Ground Floor Plan @ 1:100

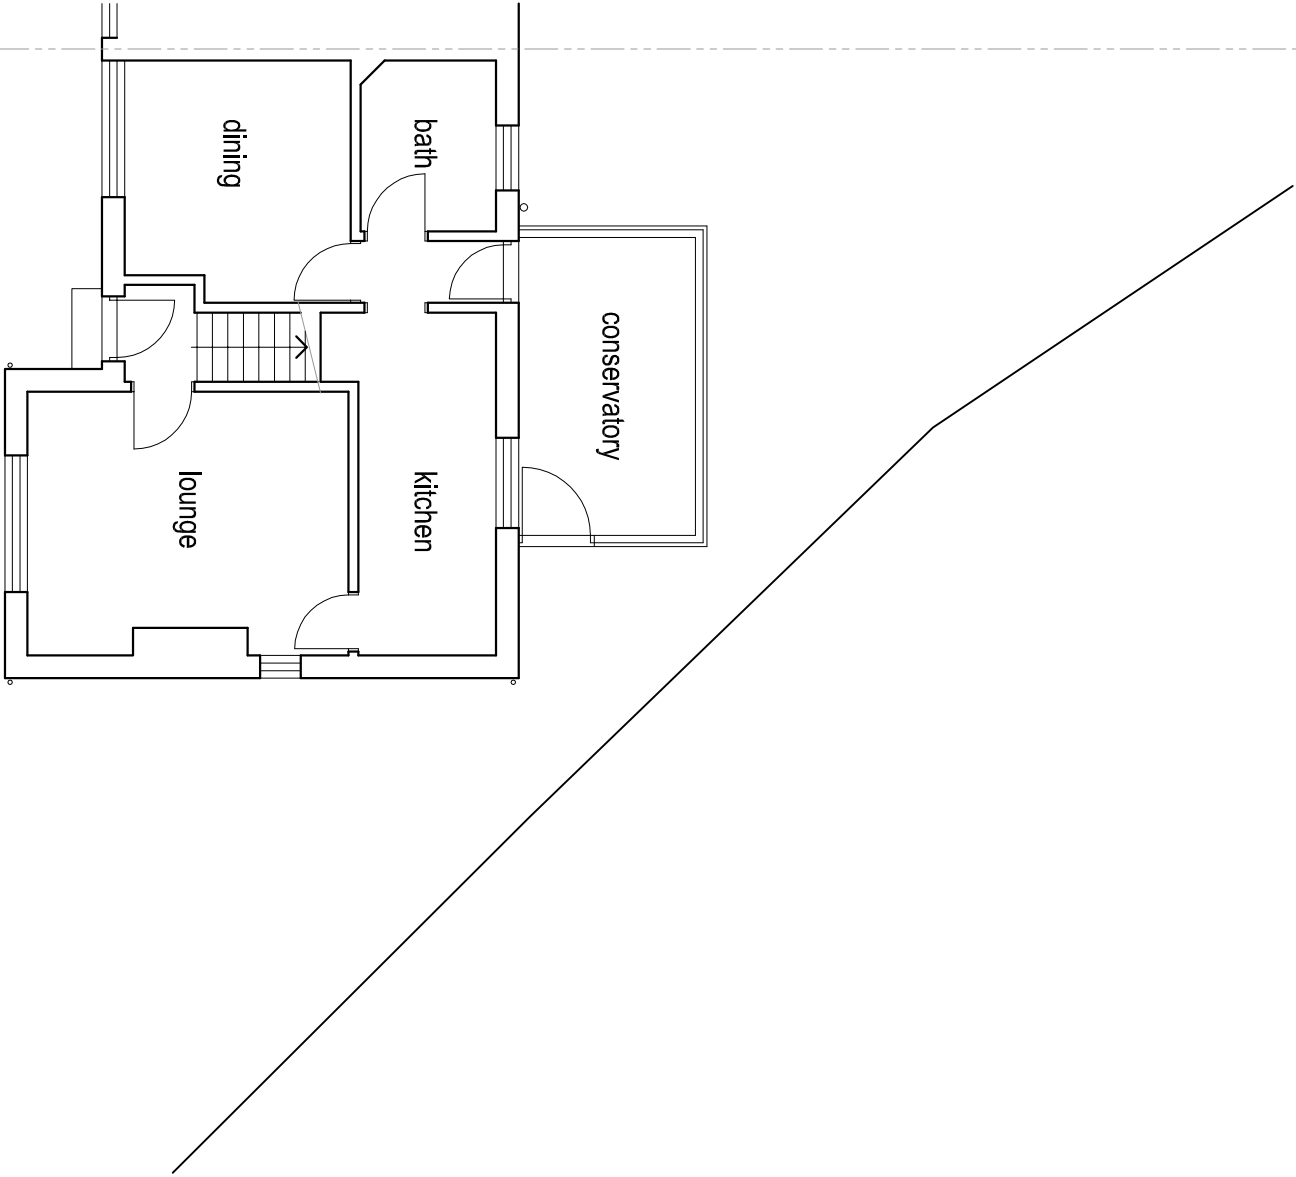
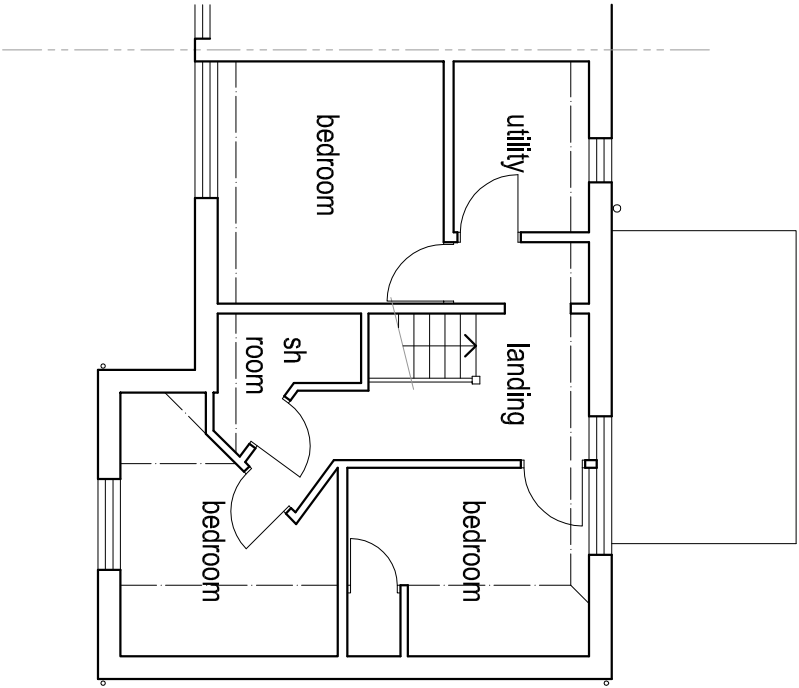
Unit 1: 39.3 sqm

Unit 2: 41.2 sqm

Unit 3: 38 sqm

Unit 1 & 2 would satisfy the requirements if there are occupied by 1 person each.

Unit 3 would need to be at least 58 sqm as it's 2 storey so it's 20sqm short of requirements.

Is it possible to amend the application to 2 No two bedroom flats at just over 61m sq each.

Block Plan

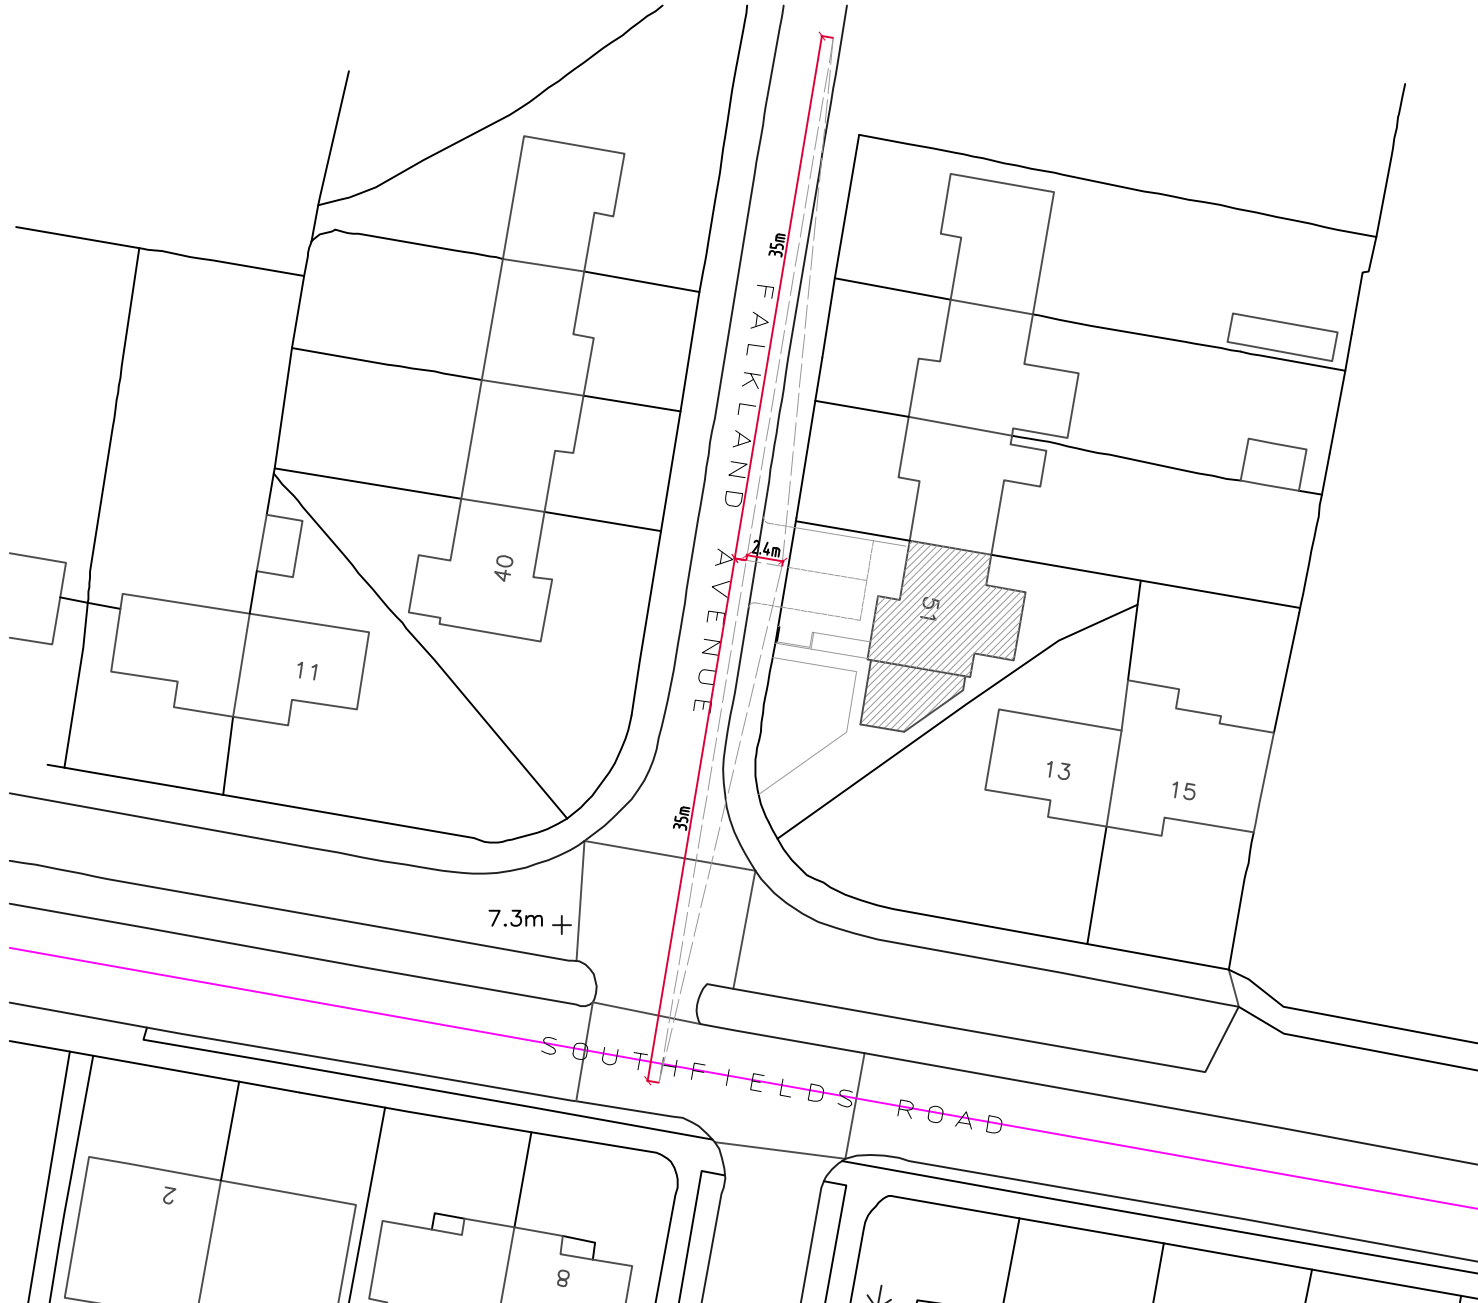
Please find the Highway comments attached. They are not objecting but do recommend a few conditions. One thing they would like changed is in terms of access, outlined below:

This proposal includes construction of two additional vehicle crossovers (VCO) to accommodate the proposed parking provision. I have consulted the Area Manager to provide their comments in relation to the proposed VCO. They have advised that rather than two separate VCOs, the full height kerb between the two proposed VCOs should be dropped, providing a wider, shared VCO. Any access works onto the public highway must be constructed under a licence obtained from WSCC Highways to a specification agreed with them'.

Could you send in an amended plan incorporating this wider single vehicle crossover please?
